**KIRKLEES METROPOLITAN COUNCIL
INVESTMENT & REGENERATION SERVICE**

DELEGATED DECISION TO DETERMINE PLANNING APPLICATIONS

Reference No: 2021/62/90219/W

Description: Erection of extensions and alterations to garage create dwelling forming annex accommodation associated with 5, Park Riding, Northgate, Honley, Holmfirth, HD9 6QL

Drawing No.
210408_ASK001

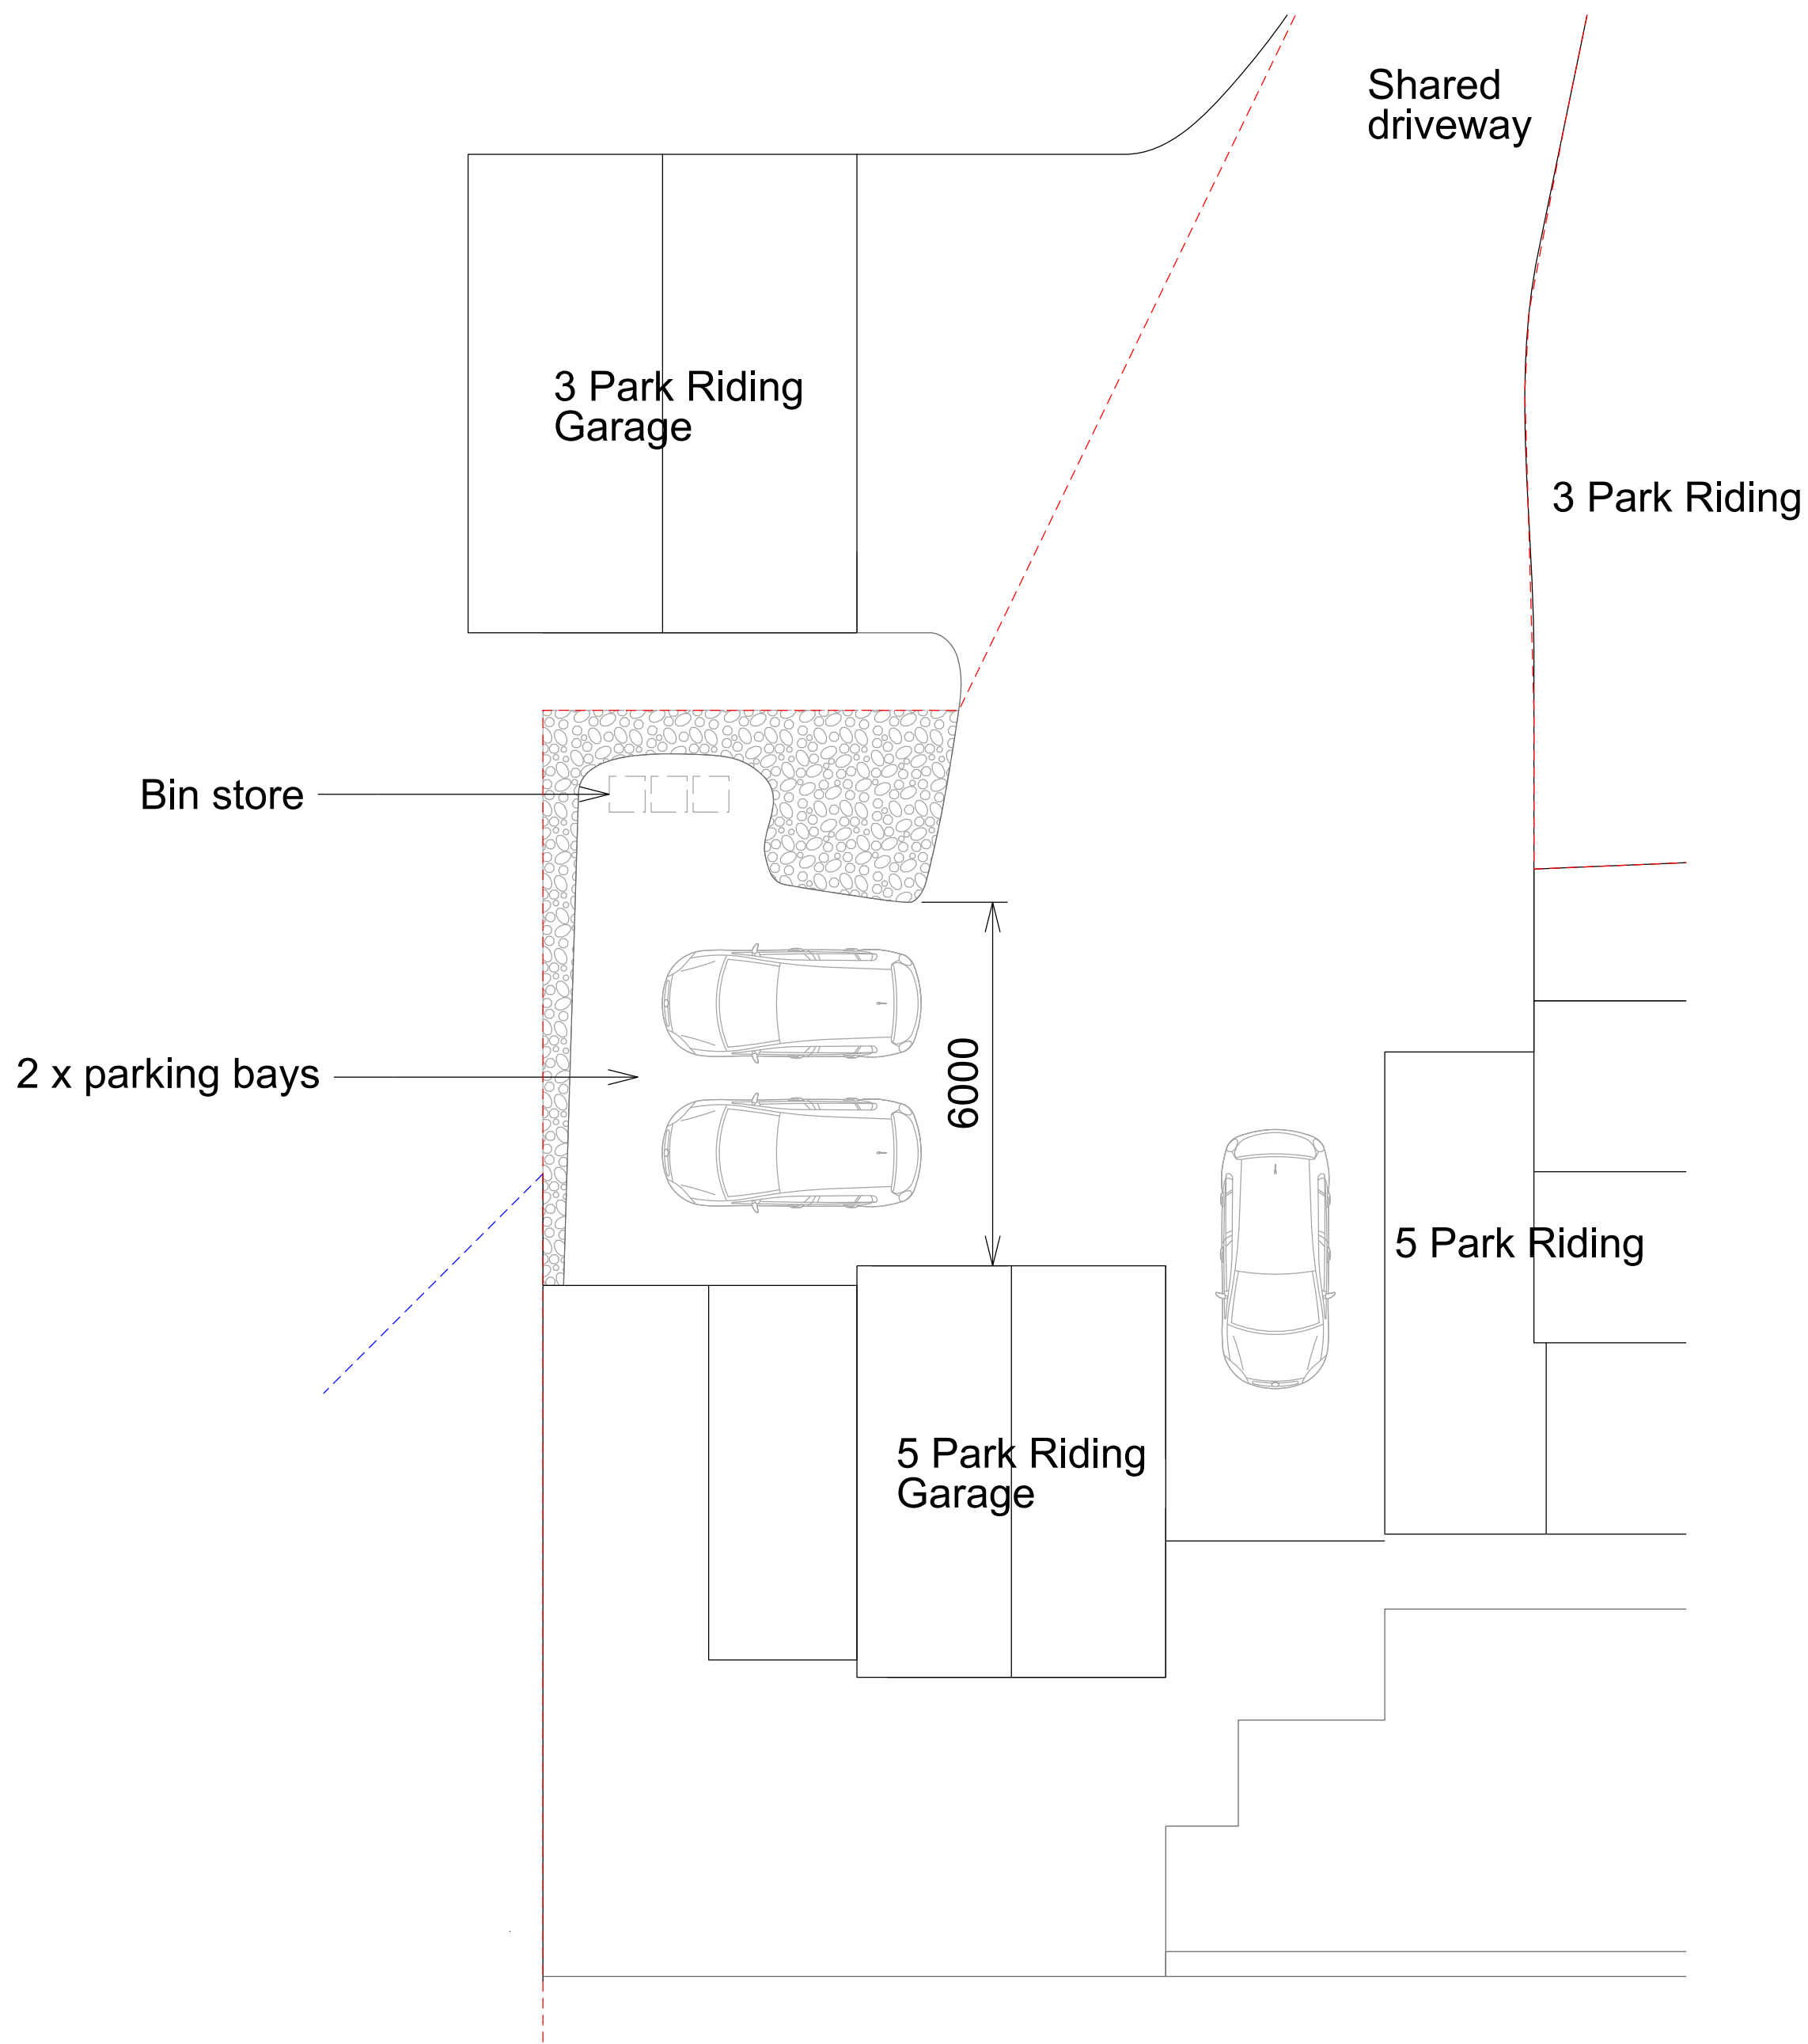
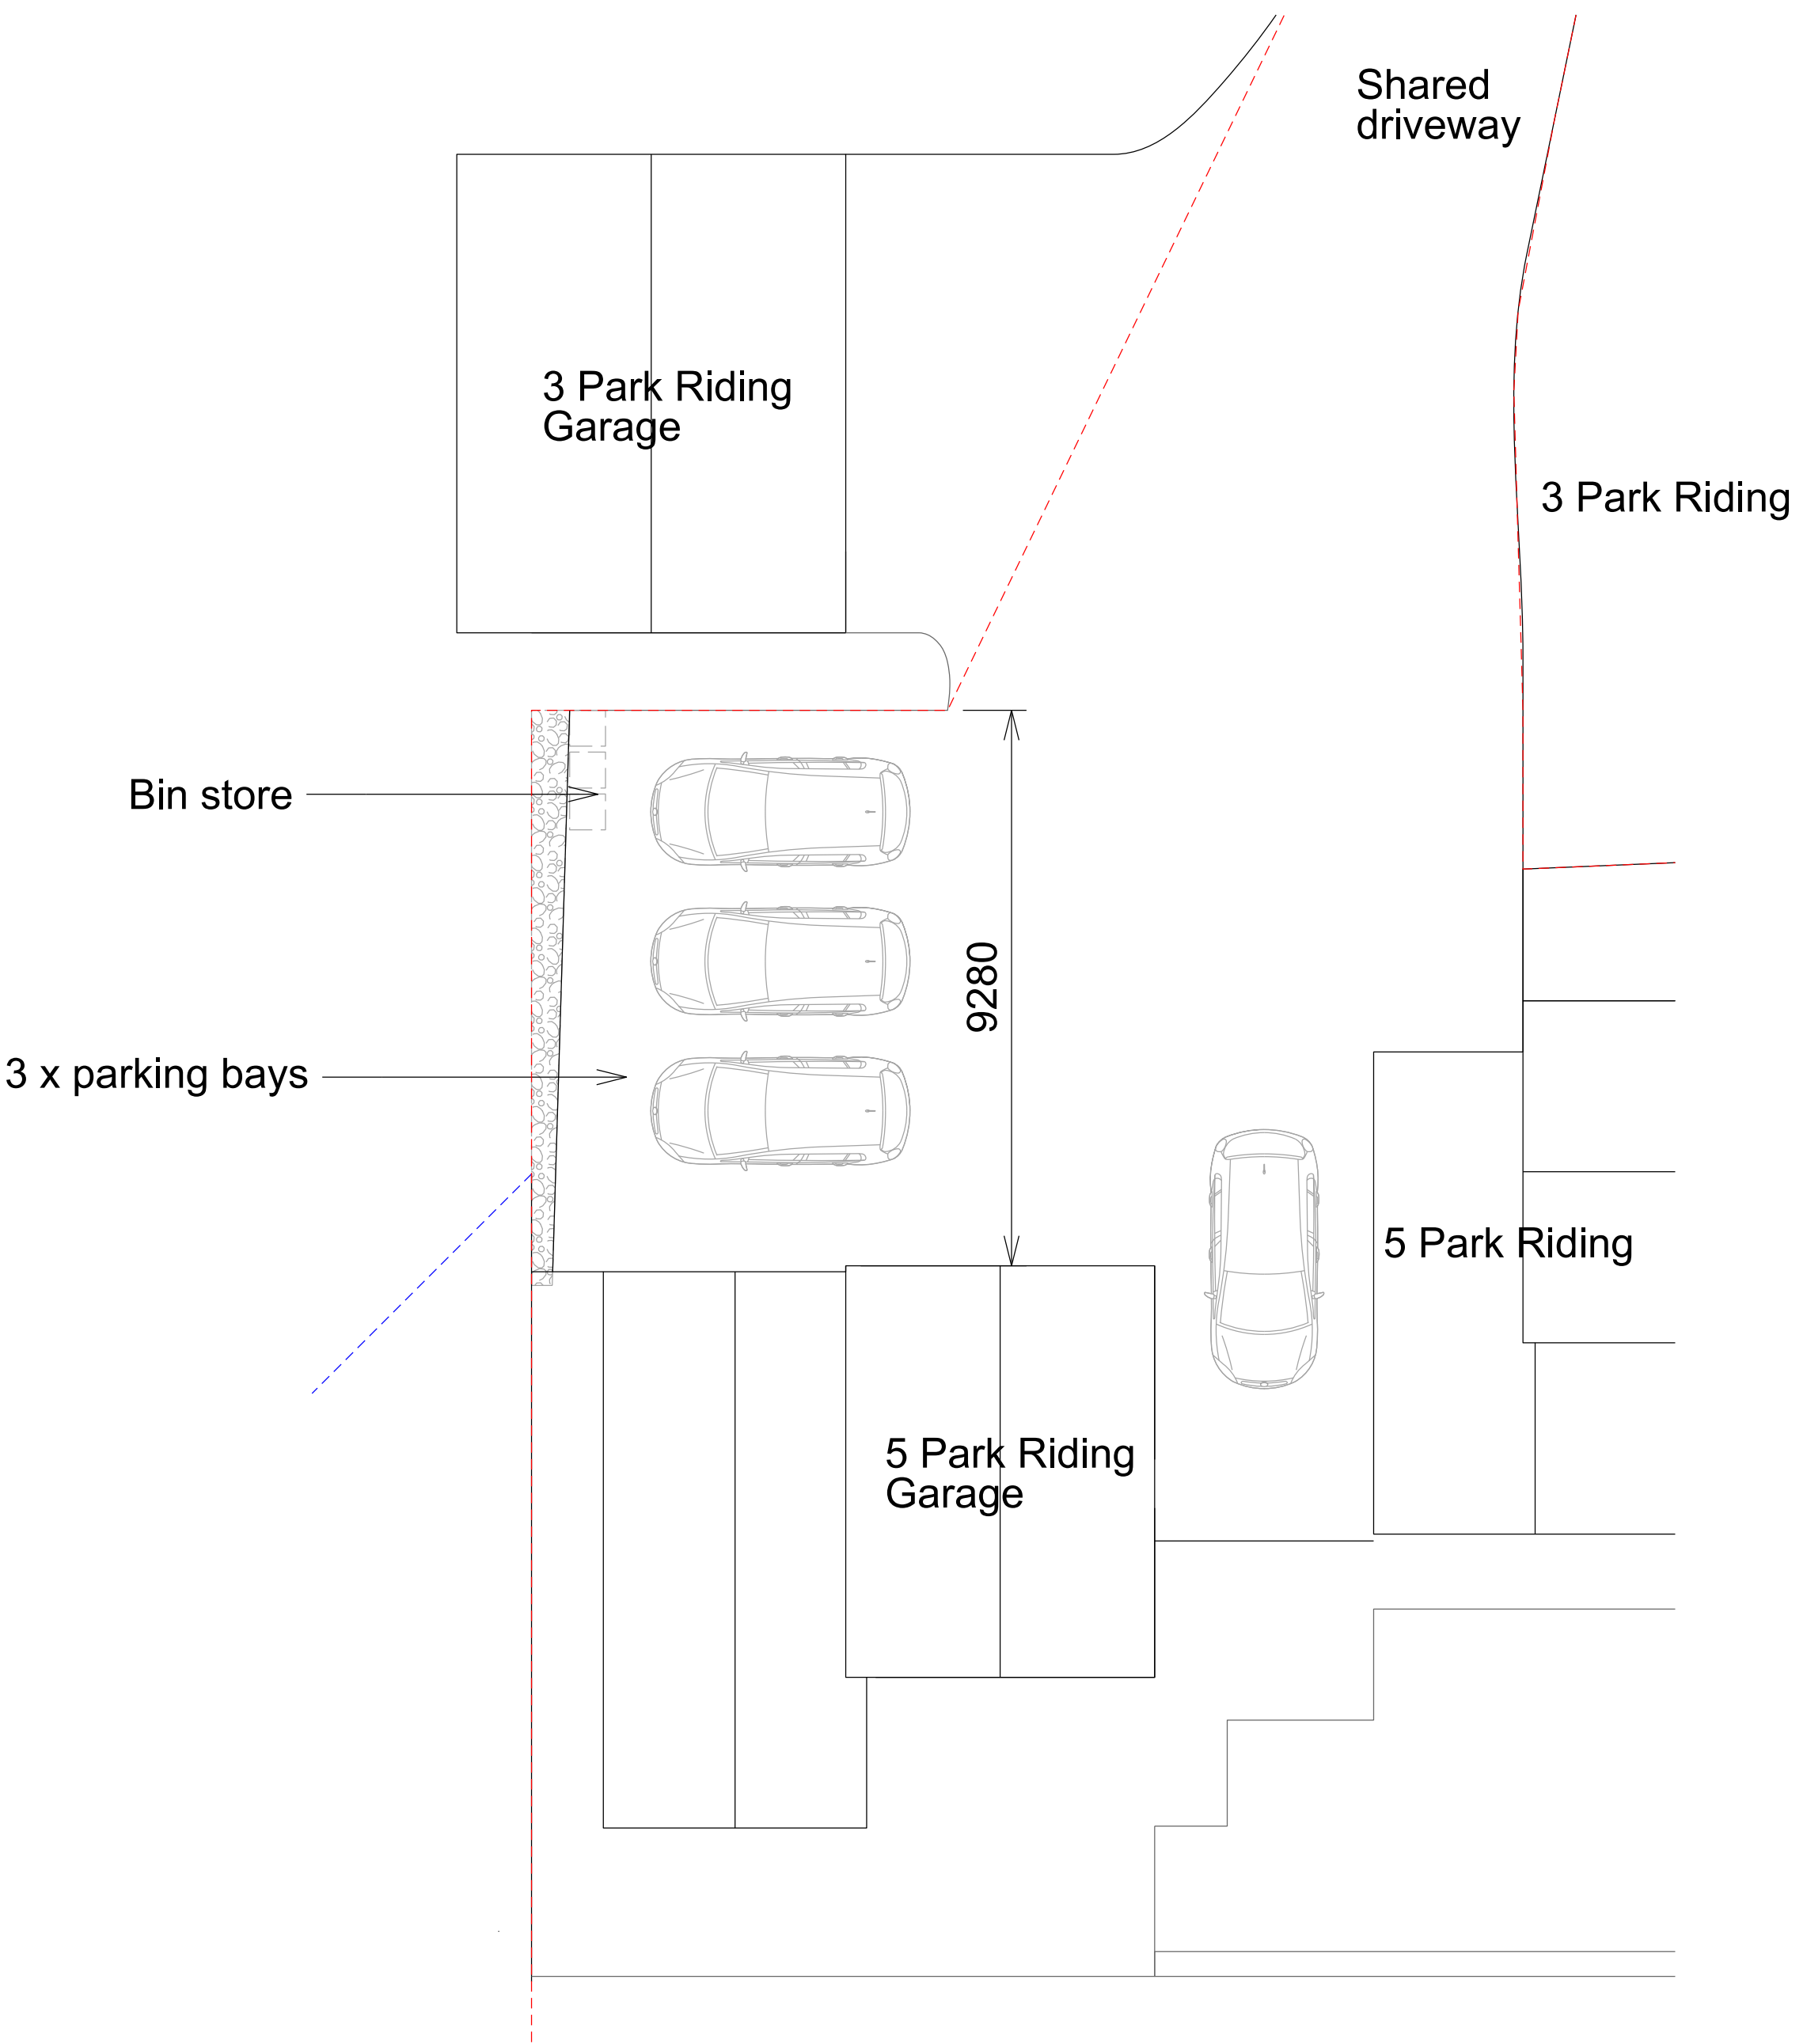
- The boundary wall shown on the plans is not in the ownership of the applicant;

objections to the red line boundary, subject to observations made to the ownership of a boundary wall and right of access shown on the submitted Parking and Bin Location Comparison Plan drawing no. 210408_ASK001 Rev 01. However, this would be a civil matter and it was confirmed by the Council's Highways team that should a fourth parking space not be able to be utilised due to this boundary wall/access, 3 car parking spaces would be sufficient provision at this site and therefore would be acceptable. In addition to this, the neighbours raised concerns over the accuracy of the proposed blue line boundaries shown on the submitted plans, as this is not specifically relevant to the location in which the application is proposed, this would be a civil matter that would fall outside the remit of this planning application.

Officer note: Unfortunately, this would be a legal matter that would need to be resolved outside of the planning application.
